RE: FIRST PARTY RESPONSE TO SUBMISSIONS RECEIVED IN RESPECT OF APPLICATION REG. REF. ACP-324015-25, A S.37L APPLICATION FOR FURTHER QUARRYING AT CLOGRENNANE, BILBOA, CO. CARLOW.

ACP REG. REF. 324015-25

Figure 8-3: Site Drainage Map

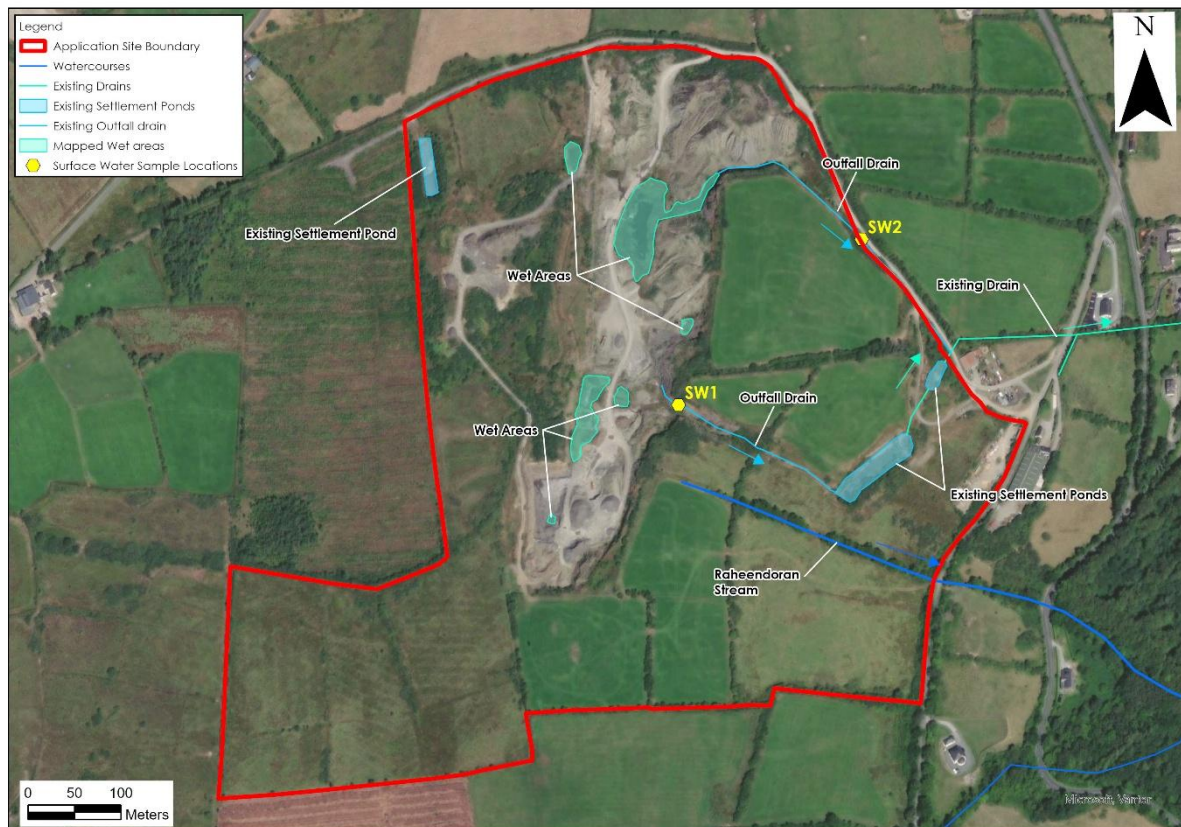
"Any settlement lagoons should have been maintained and monitored carefully and should be constructed from the clayey subsoil that is present directly underneath the residual peat over much of the site and will operate as sealed lagoons. There is no detail on the construction or management of lagoons throughout the operational phase of this quarry. This mitigation measure prevents a loss of water through the base of the lagoons and will prevent any silt fines from the lagoon(s) going to groundwater.

There is no information on the rate of dewatering, the pump specification or the location of discharge at the Site. The course of the Raheendoran Stream has been altered by the historic quarrying activities the drainage affect and groundwater distribution regarding this activity which was done without an EIA at the time needs careful consideration."

Hydro-Environmental Services (HES) have reviewed the Submission made by the HSE in respect of hydrology and Hydrogeology and have prepared a full response to all queries and concerns raised, which is provided in full in Appendix B of this Response.

Figure 9.3: Annual Mean Dust Deposition Rate (mg/m²/day) – Proposed Operations Scenario

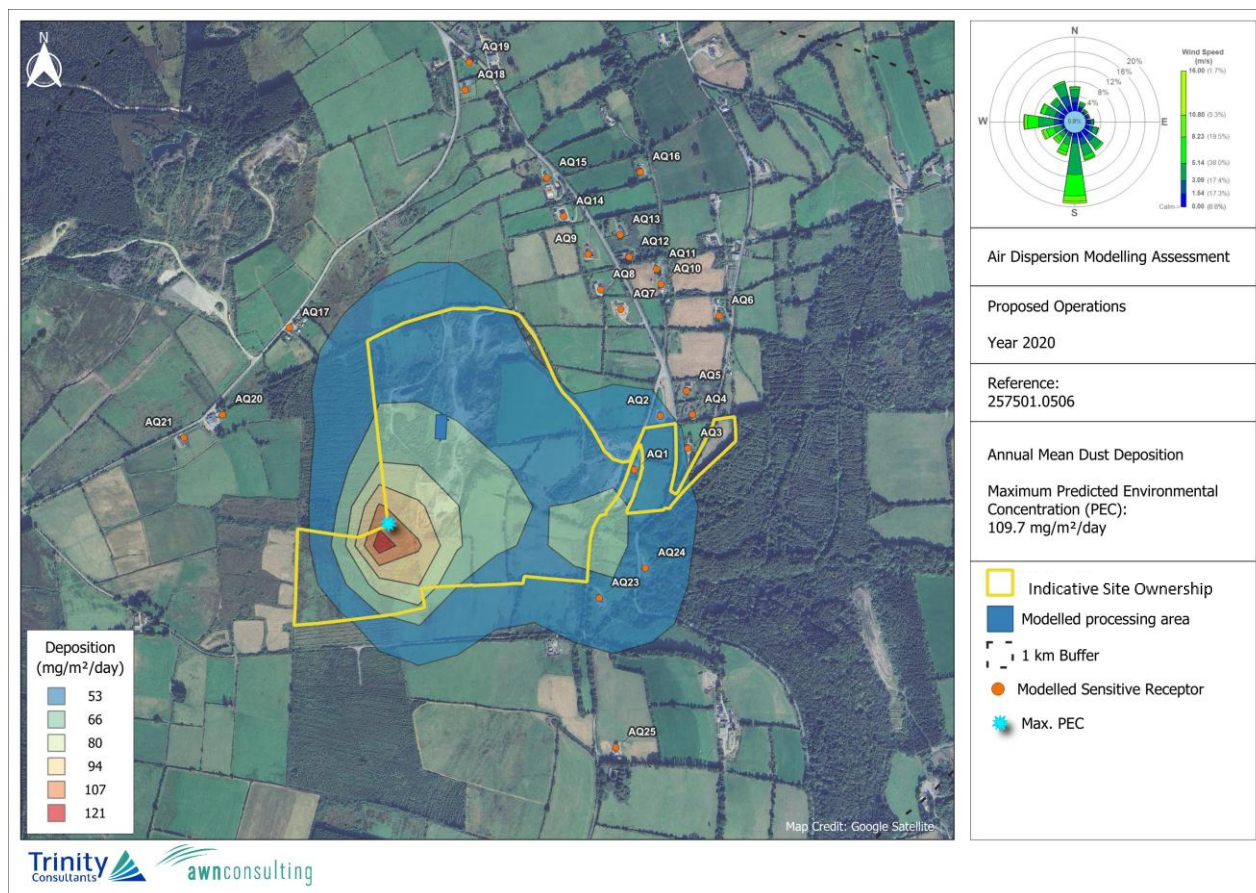
“The NEHS recommends the TA Luft limit value of 350 mg/m2/day to be adopted to evaluate potential dust deposition impacts from the operational phase of the quarry and extension if granted.”

“The HSE recommends that the TA Luft limit value of 350 mg/m2/day is adopted to establish the impact operational phase quarrying activities from the proposed development on the surrounding environment. This limit value has been used in Chapter 9 – Air Quality as set out in Section 9.2.1.3 and Section 9.4.3.1.1 of Chapter 9 in the EIAR. It is stated in Section 9.7 of Chapter 9 – Air Quality that monitoring at the site boundary should be undertaken, to evaluate whether compliance with the TA Luft limit value of 350 mg/m2/day is achieved, once the quarry is operational and to evaluate whether mitigation measures are working satisfactorily.

If planning is granted the Applicant will commit to a condition that compliance with the TA Luft limit value of 350 mg/m2/day (averaged over a year period) is required at the site boundary. Monitoring of dust deposition in accordance with the Bergerhoff methodology will be employed to assess compliance. This is industry standard for quarrying and is recommended by the EPA in Environmental Management Guidelines - Environmental Management in the Extractive Industry (Non-Scheduled Minerals).
